09 March 2020

Case Number EQ/20/50092
Proposal Agricultural dwelling
Site Wicksmead, Penn Common Road, Bramshaw, Lyndhurst,
SO43 7JL

Project Title: WICKSMEAD, PENN COMMON BRAMSHAW. SO43 7JL		
Drawing Title: FLOOR PLANS		
Client: MR & MRS PARKS		
Scale: 1:100 @ A3	Date: SEPT 20	Drawn by: OE
Job No: W200 269	Drawing No: SK01	Rev: J

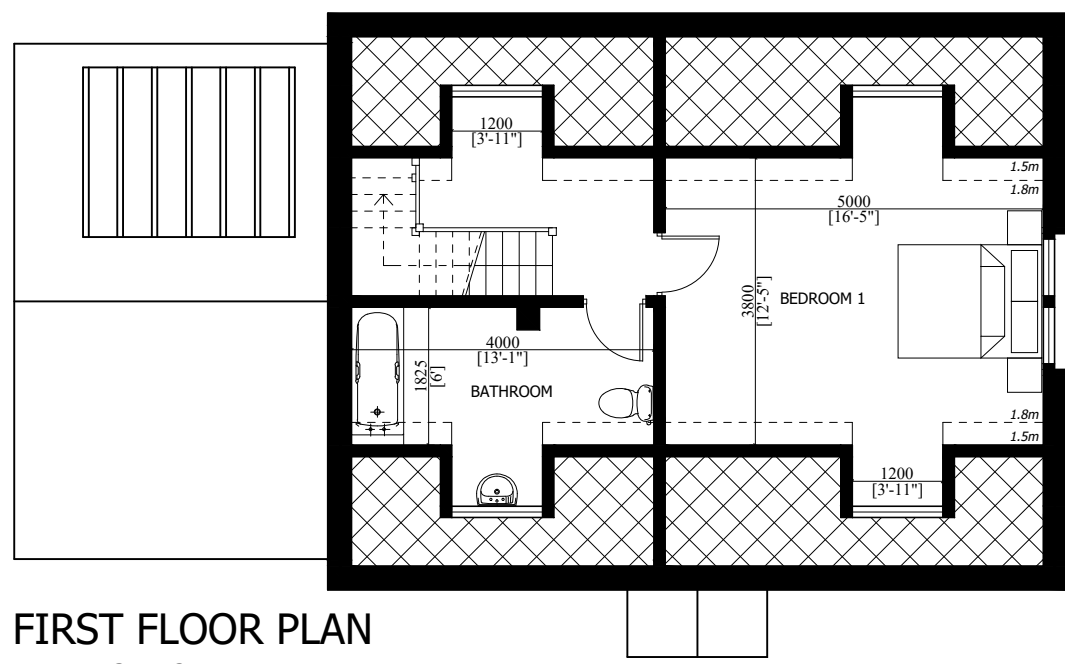
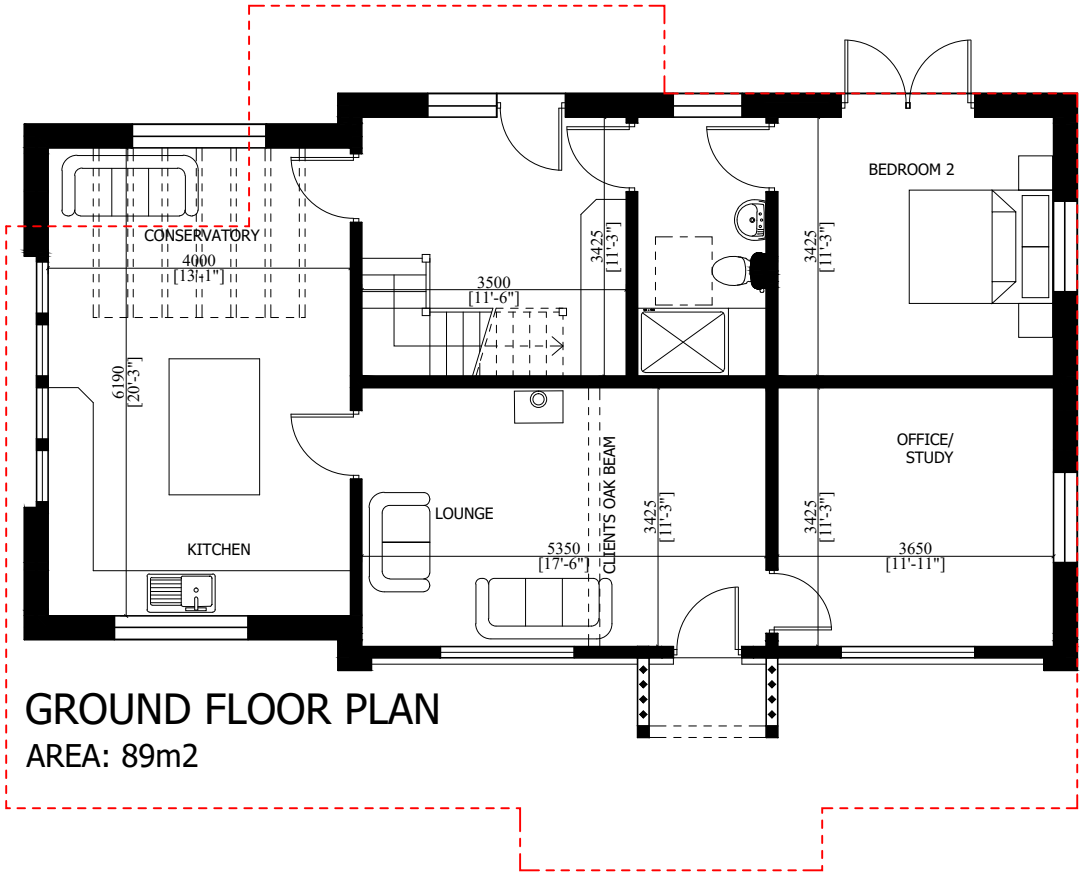
Habitable floorspace is calculated as gross internal floorspace including all floors and stairwells. Accommodation within the roofspace is included where there is natural light (e.g. via a dormer window or roof light), a permanent staircase and headroom of at least 1.5 metres. Therefore, from the drawings the proposal includes fixed stairs and is used for a bedroom (accommodation) and either with or without a window, floorspace with a head height of above 1.5 metres would be included within the floorspace calculations, this would include the 'attic space' and possibly the void.

Project Title: WICKSMEAD, PENN COMMON BRAMSHAW. SO43 7JL		
Drawing Title: ELEVATION		
Client: MR & MRS PARKS		
Scale: 1:100 @ A3	Date: SEPT 20	Drawn by: OE
Job No: W200 269	Drawing No: SK02	Rev: H

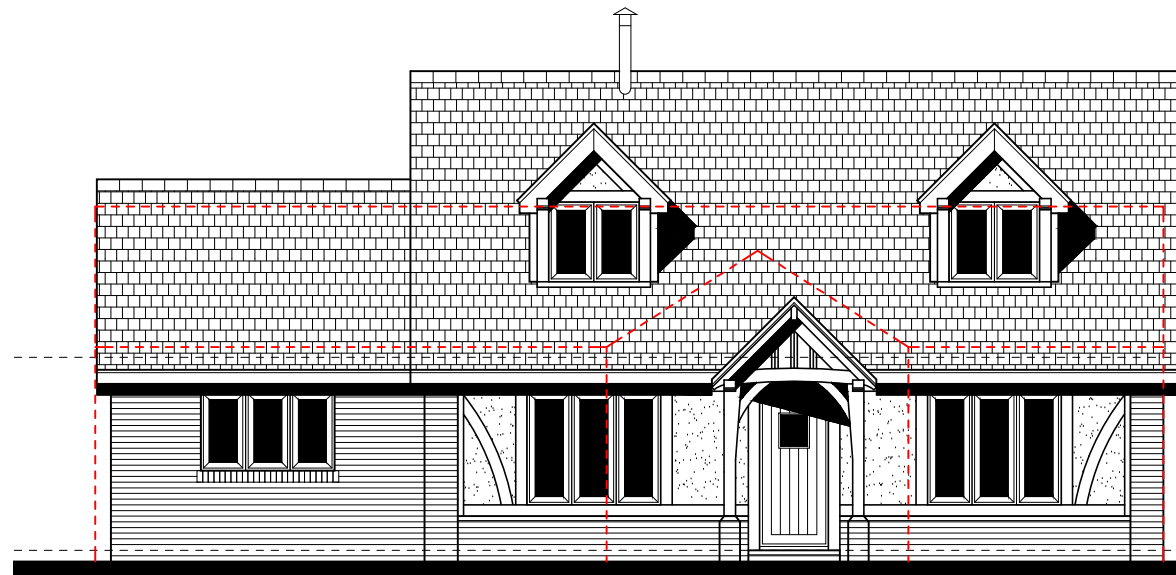
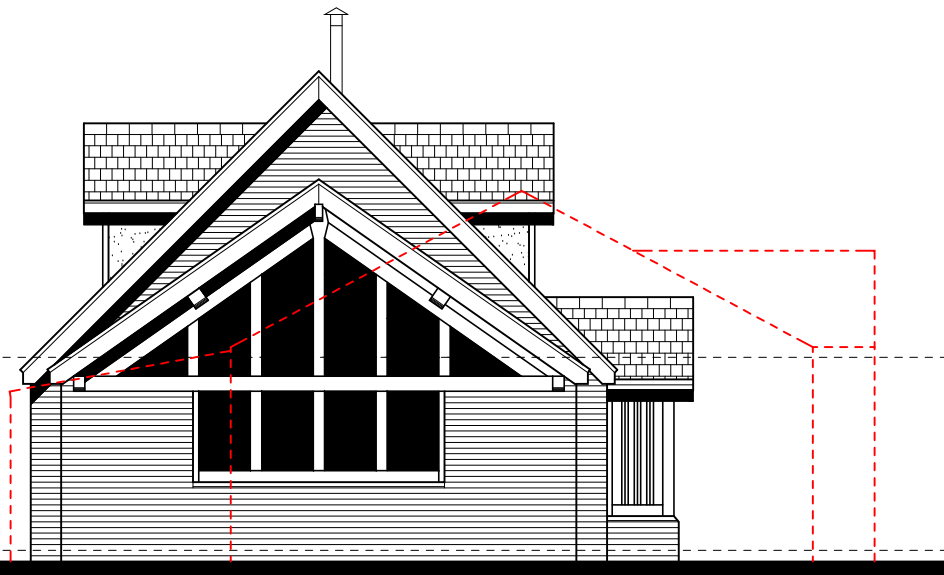
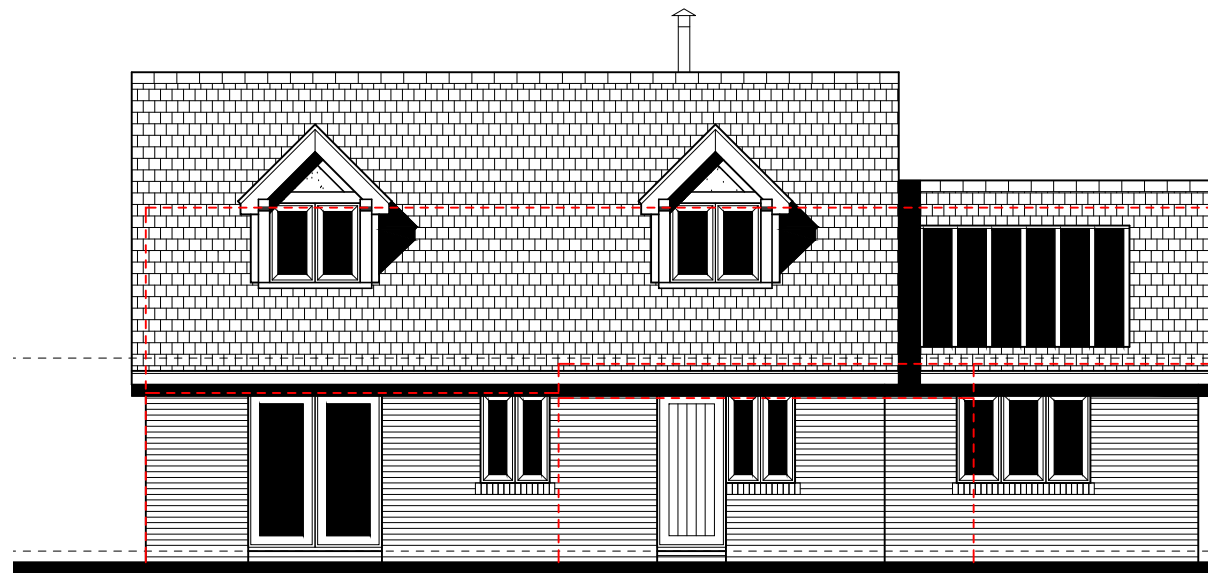
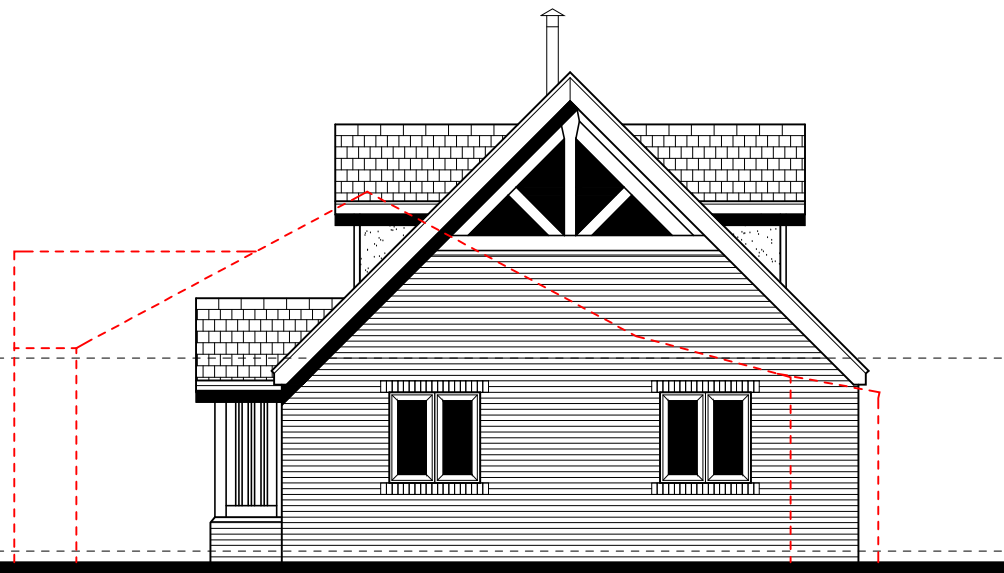
With regards to my comments about the gable end windows, these would be of a design that I would not recommend and careful consideration would need to be had to the windows because the site is directly adjacent to SSSI. Light pollution and excessive glazing would be a material planning consideration.
